Project Title: TRACT H SAWMILL **Building Permit #:** _____ **Hydrology File #:** _____
DRB#: _____ **EPC#:** _____ **Work Order#:** _____
Legal Description: TRA A-2 PLAT OF TRACTS A-1 A-2 AND A-3 LANDS OF WILLIAM ANDREW MCCORD CONT 20290AC **UPC:** 101305817952322307
City Address: 1921 BELLAMAH AVE NW ALBUQUERQUE, NM

October 4, 2022

**RE: TRACT H SAWMILL
1921 BELLAMAH AVE. NW
TRAFFIC CIRCULATION LAYOUT RESPONSE TO COMMENT**

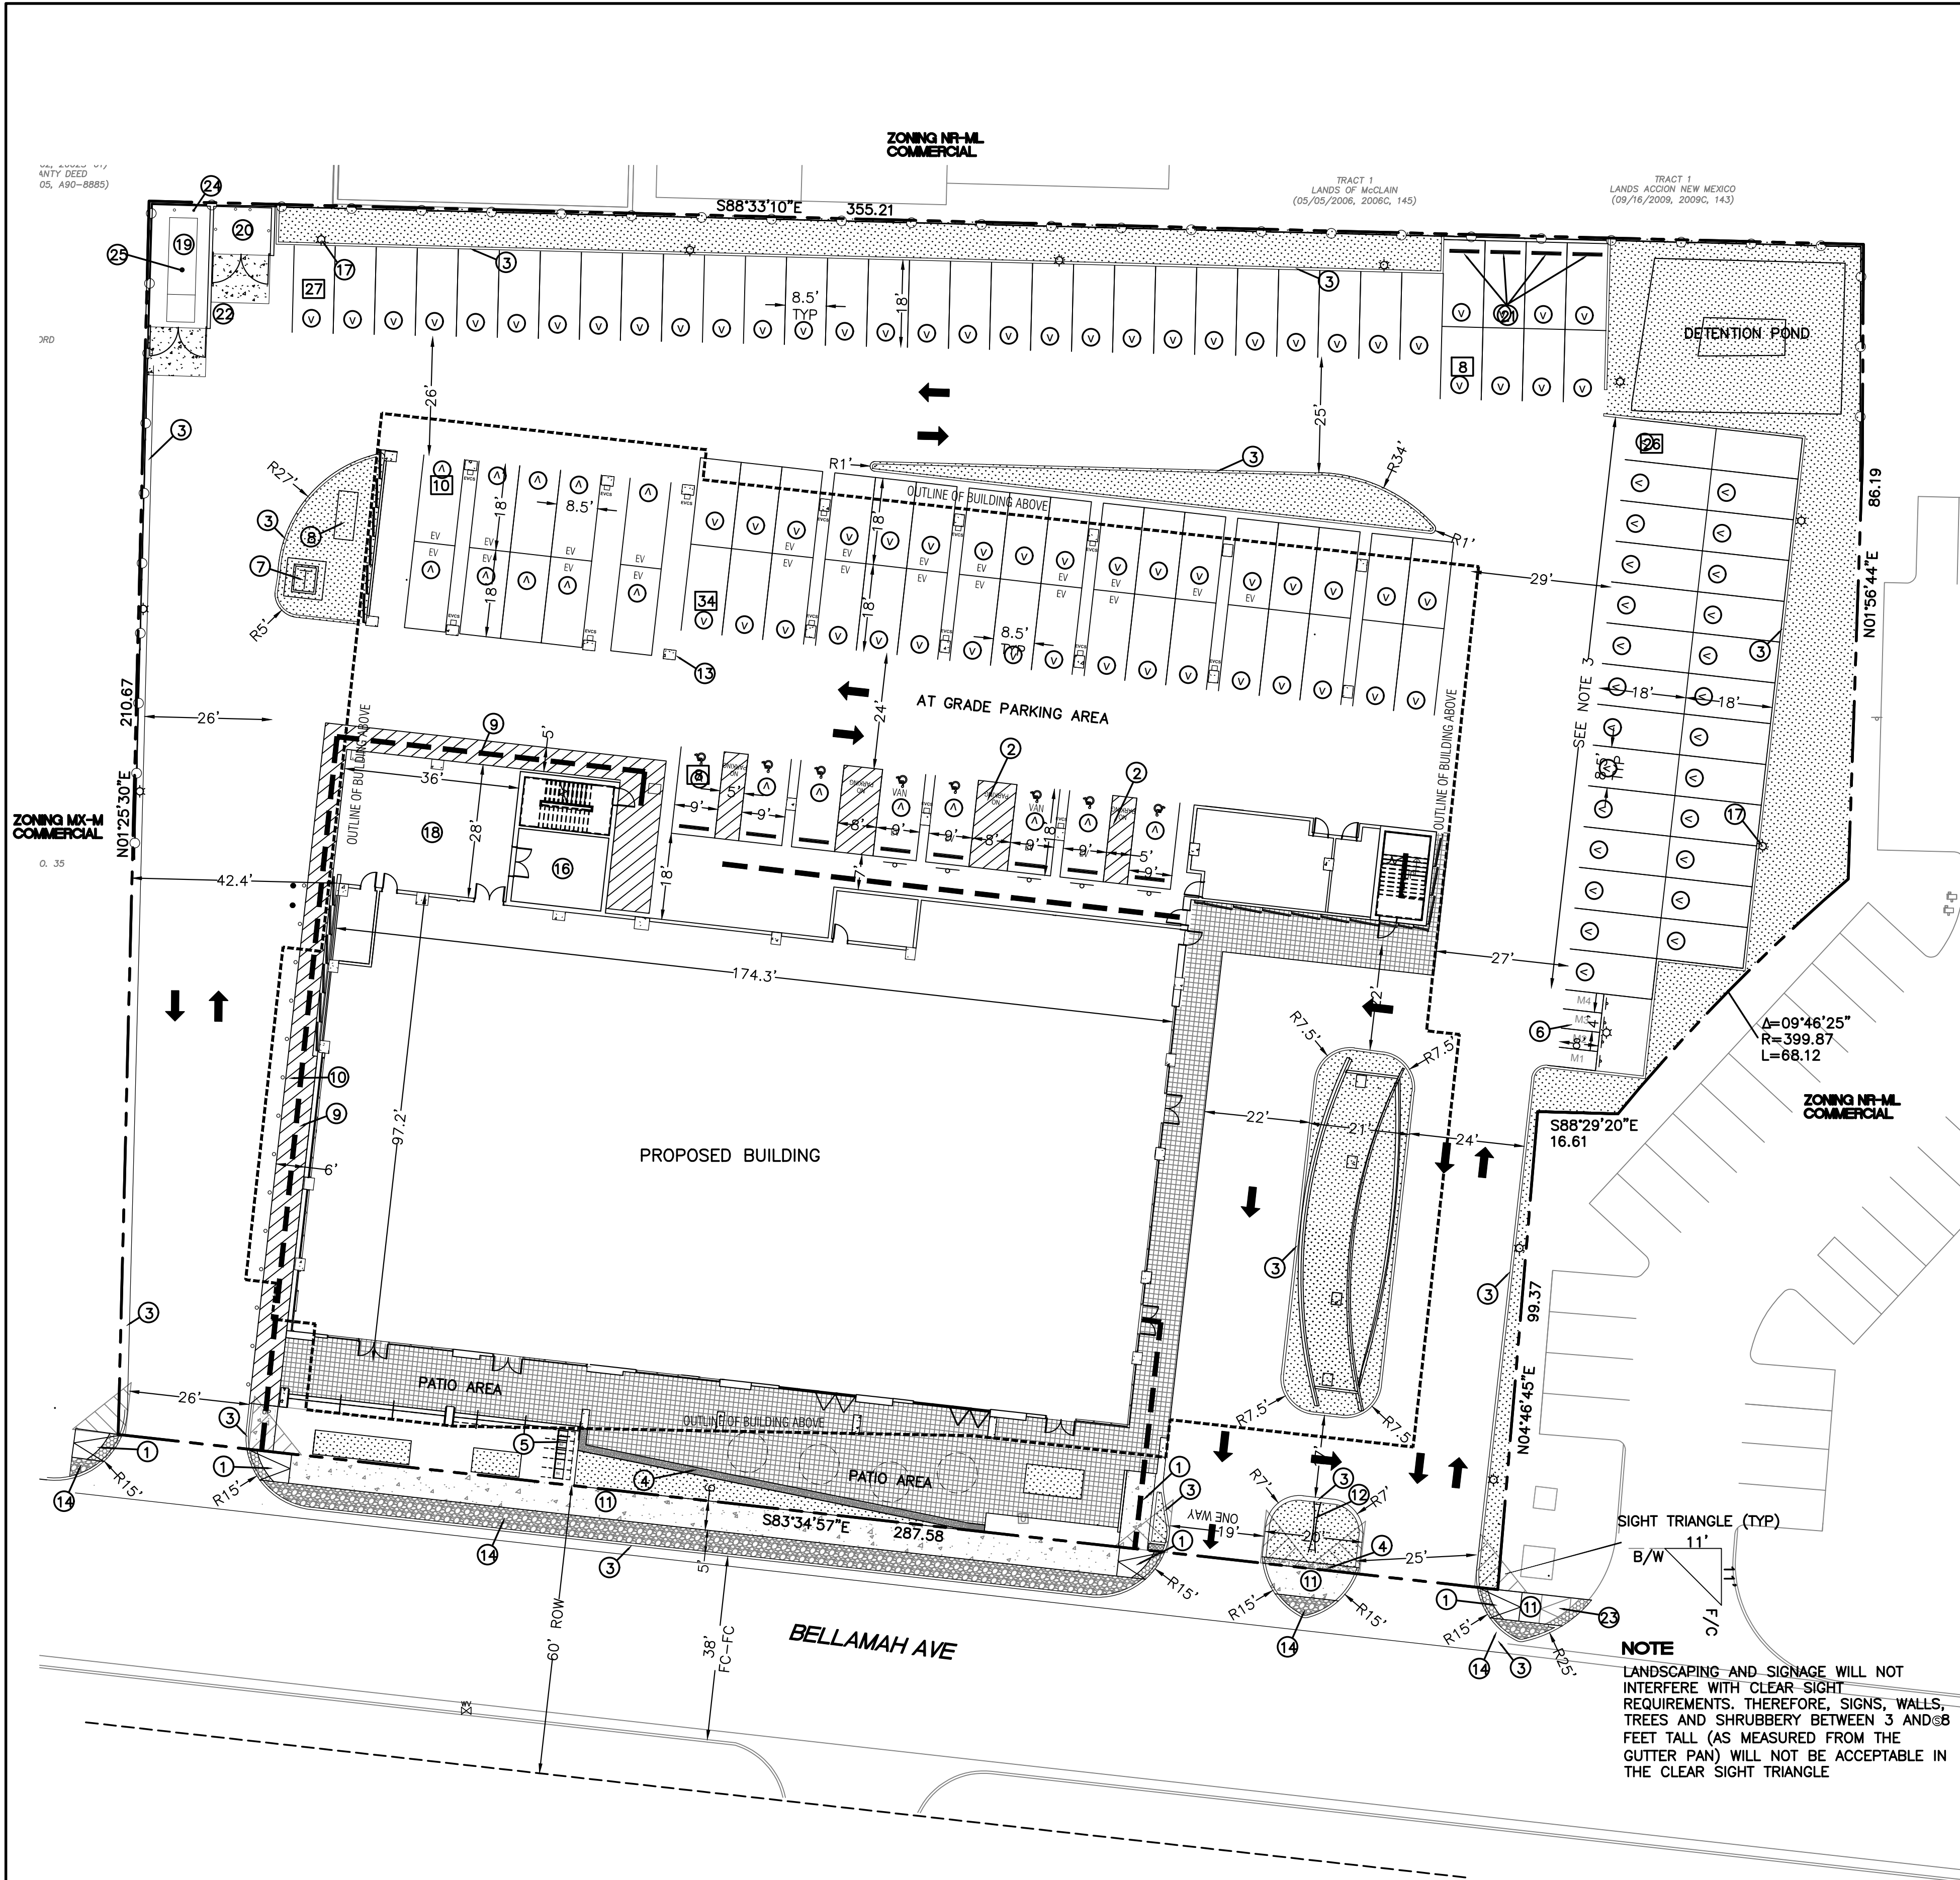
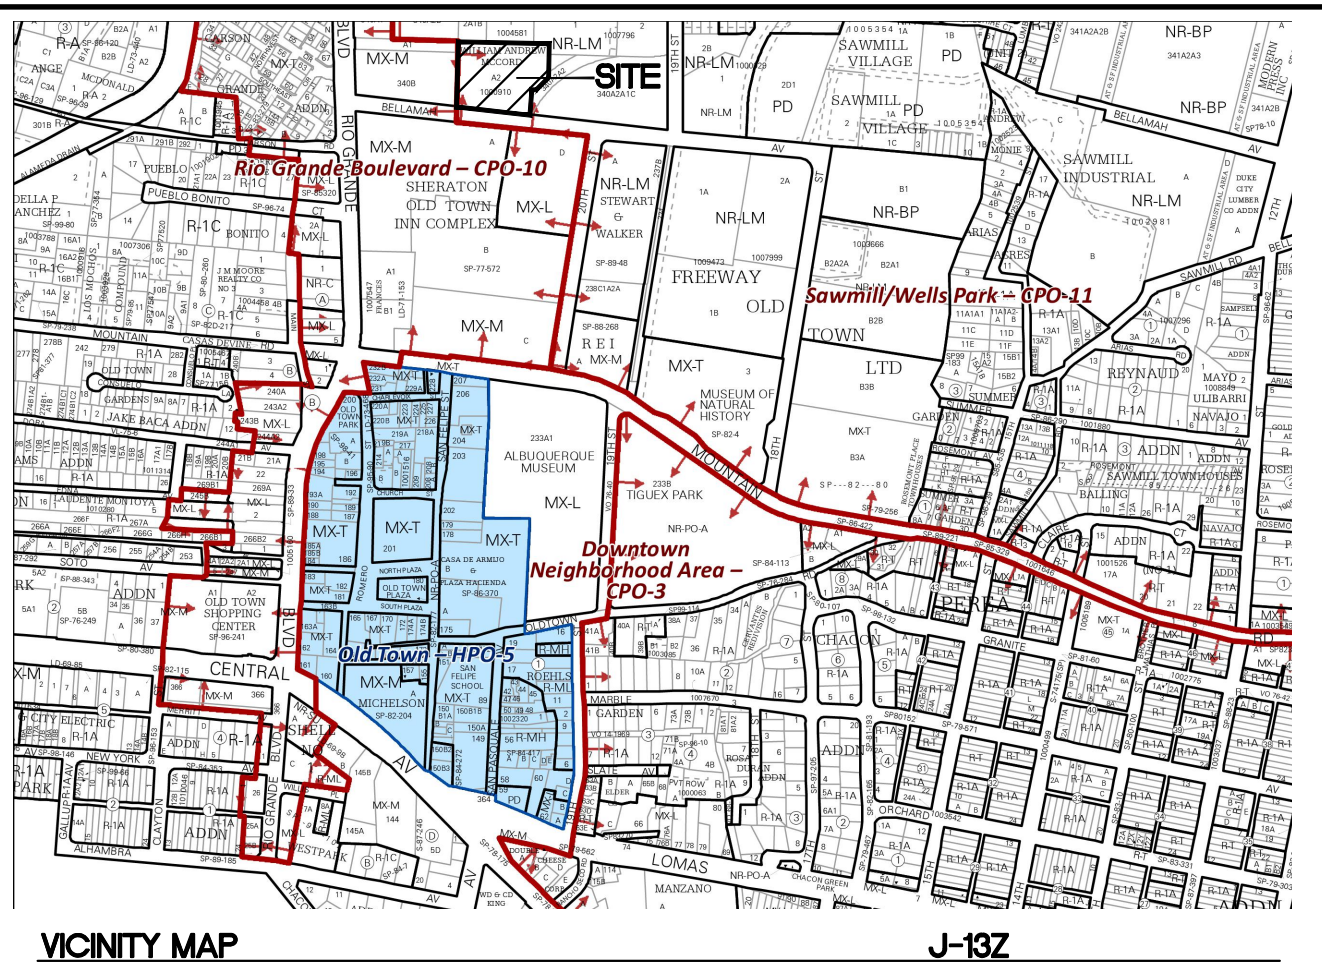
1. Site Access: Please provide Curb Return design for the driveways access of Bellamah Ave. and reference COA std dwg. 2426. Also, the One Way drive (Exit Only) shall have "Do Not Enter" signage and pavement marking. Please provide details for signage and pavement marking. Please note that the GIS shows there are two existing curb return driveways access.
We have added curb returns to the access locations and placed the one way markings requested.

2. Please reconfiguration parking spaces layout. The parking layout should provide continuous flow of traffic through the lot.
All of the parking shall be via valet parking. We've added a note to the plan stating such which should allow for the double parking shown on the plan.

3. ADA curb ramps must be updated to current standards and have truncated domes installed.
All ADA curb ramps are to current standards and show the truncated domes.

4. Per the IDO, a 6ft. wide ADA accessible pedestrian pathway is required from the public sidewalk to the building entrances. Please clearly show this pathway and provide details.
The ADA route is now shown on the plans via a thick dashed line. This area is all sidewalk and a detail is shown on Sheet DET-1.

5. Per DPM, a 6 ft. wide ADA accessible pedestrian pathway is required from the ADA parking stall access aisles to the building entrances. Please clearly show this pathway and provide details.
The ADA route is now shown on the plans via a thick dashed line. This area is all sidewalk and a detail is shown on Sheet DET-1

6. Define ADA pathways by labeling of ramps, flush pavement, dimensioning of pathways, doorways, etc.
The ADA pathways are defined on the plans as requested.

7. ADA accessible pedestrian pathway should not be placed behind parking space or adjacent to a vehicular way. Vehicle and pedestrian/wheel chair conflicts should be avoided as much as possible.
The ADA route from the ADA parking to the building is in front of the parking stalls and does not have any pedestrian/vehicular conflicts.

8. Parking areas shall have barriers to prevent vehicles from extending over public sidewalk, public right-of-way, or abutting lots.
Parking bumpers were added to the four parking spaces where this occurs.

10. Provide a copy of Fire Marshal approval.
The approved Fire One Plan is attached.
11. It is not apparent what type of pavement surface is being proposed. A hard driving surface will be required as part of this proposed project for parking area and drive aisles.
All paved areas shall be asphalt unless otherwise specified on the site. A note was added to the plan stating this.

12. Please specify the City Standard Drawing Number when applicable.
The City Standard Drawing Numbers are listed where applicable.
13. Add a note stating, "All broken or cracked sidewalk must be replaced with sidewalk and curb & gutter." A build note must be provided referring to the appropriate City Standard drawing.
This note was added to the Site Plan.
